Second Tee Business Park - Unit 1 - Traffic Comments

Fri, Apr 21, 2017 at 11:01 AM

SHEET TITLE
SITE LAYOUT, UTILITY AND
LANDSCAPE PLAN

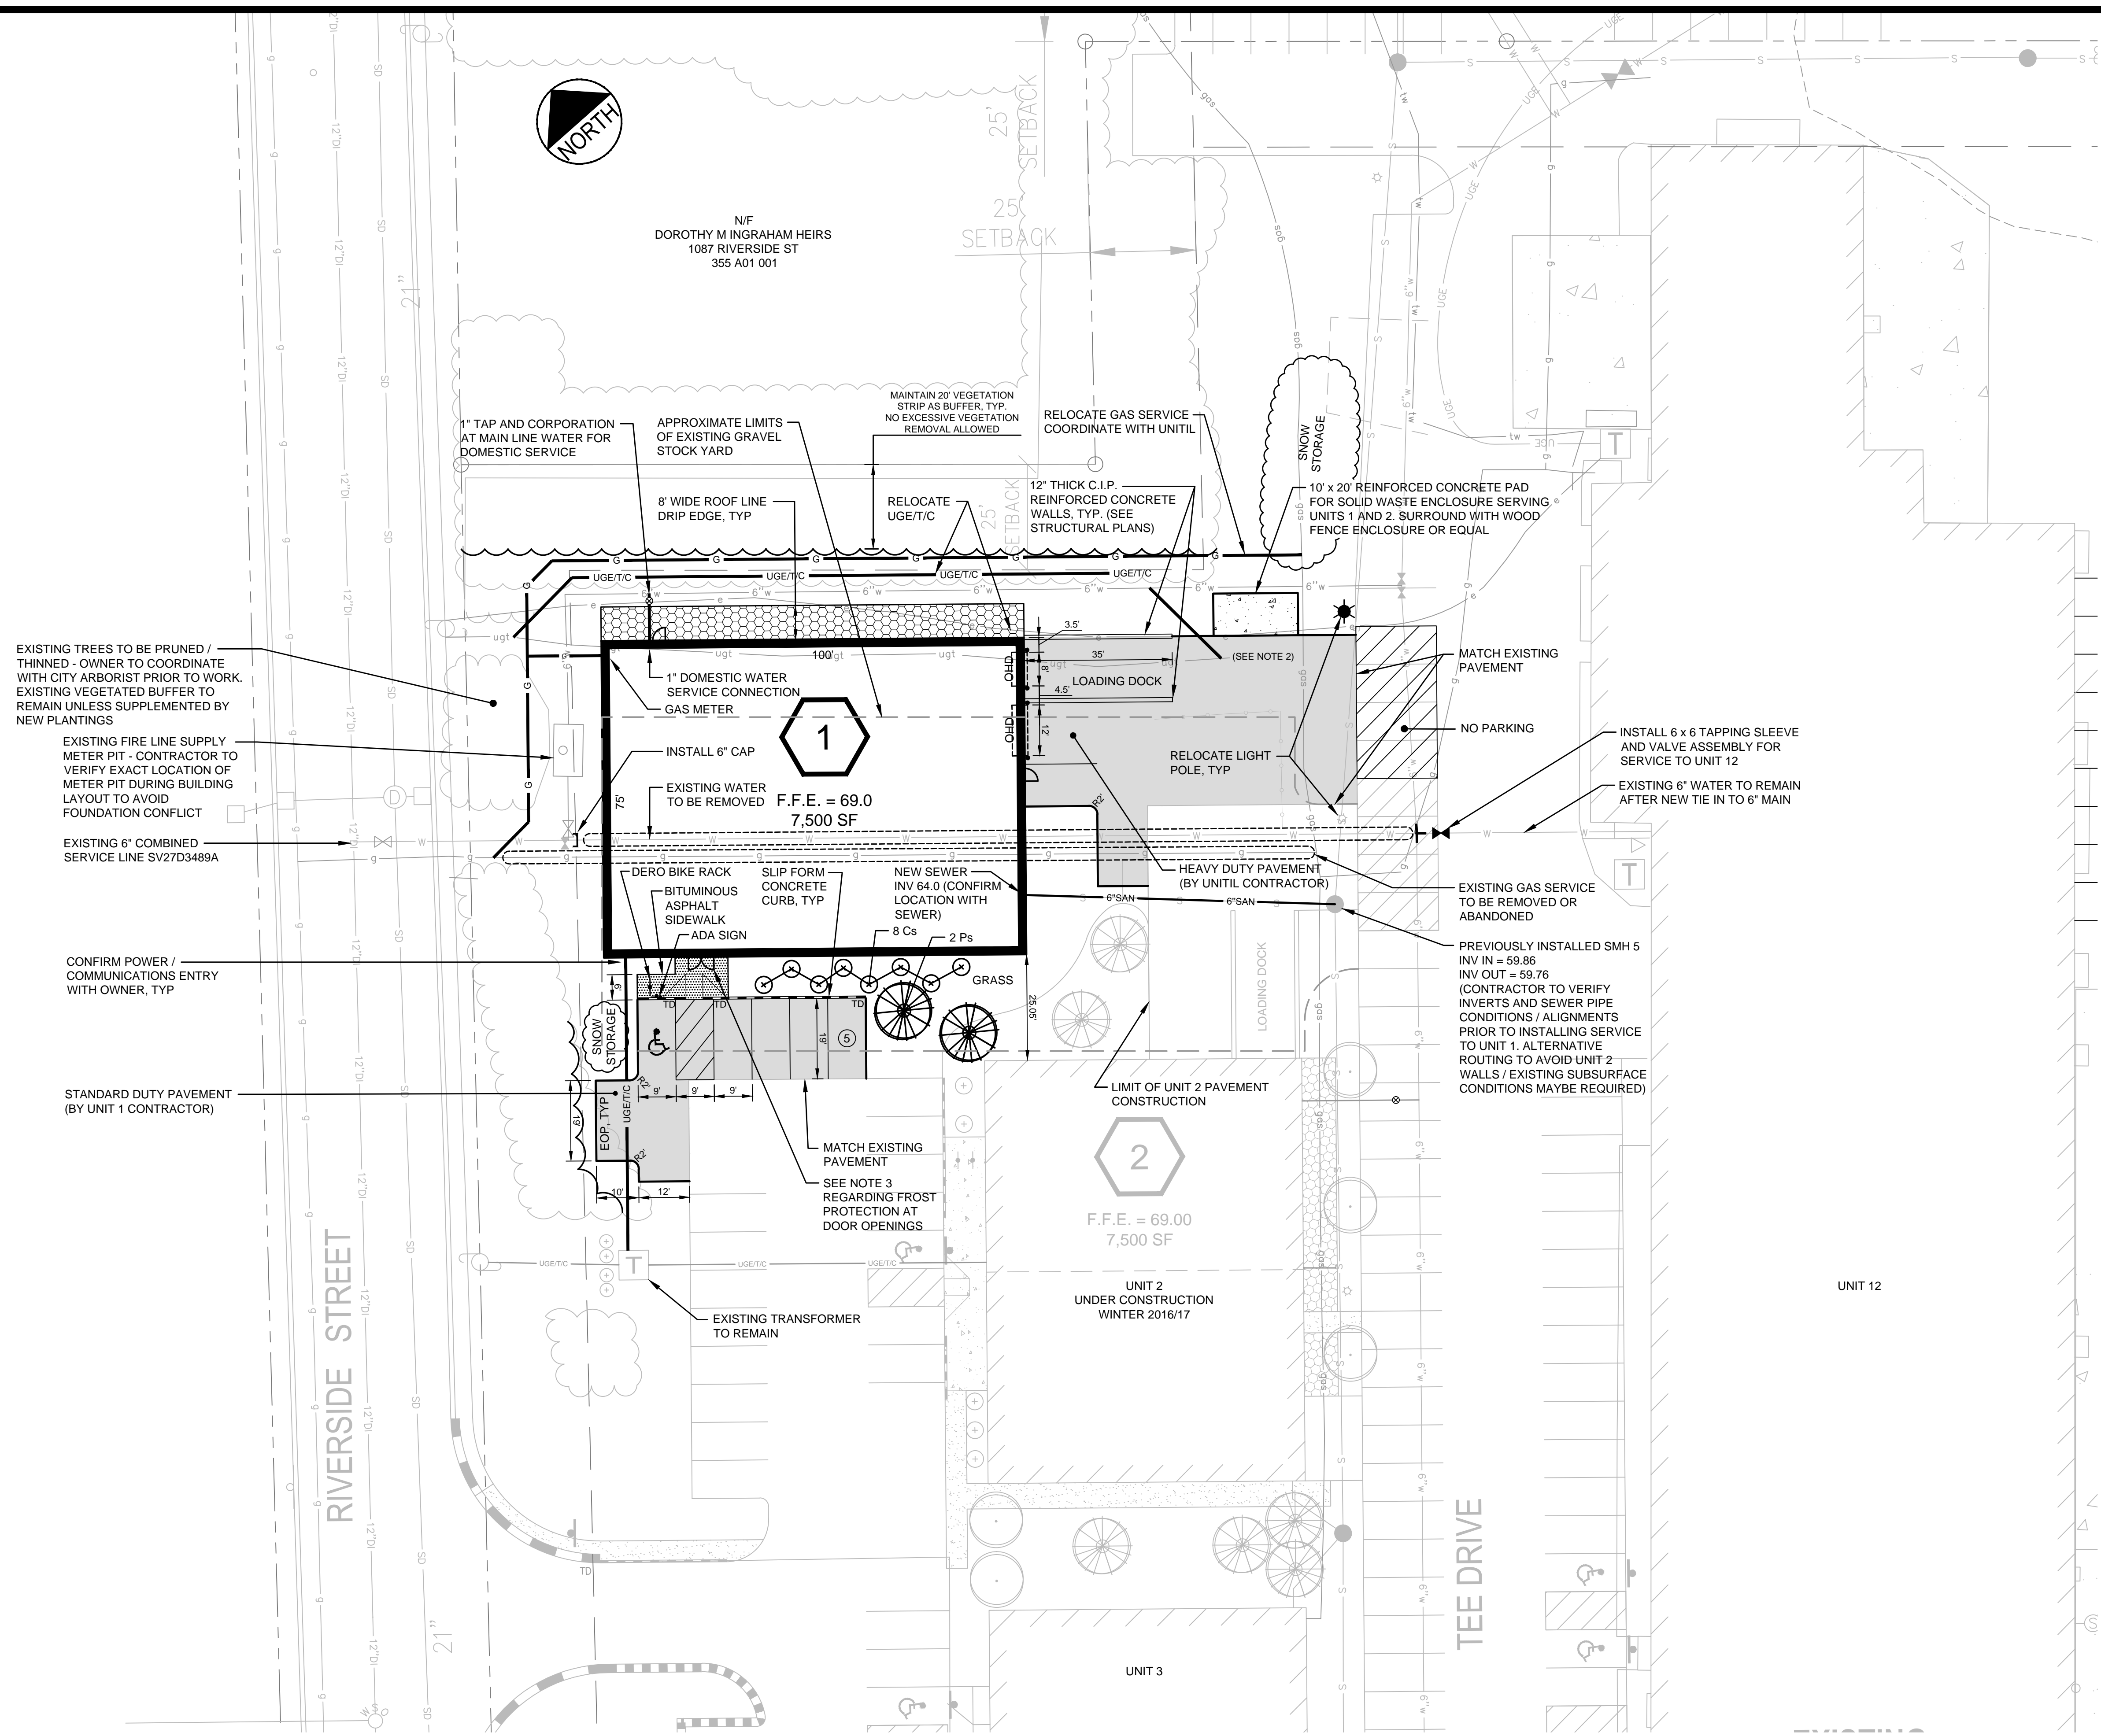
- I find the general layout of site to be acceptable. The applicant should provide a pedestrian facility connection from the building to the sidewalk on Riverside Street.
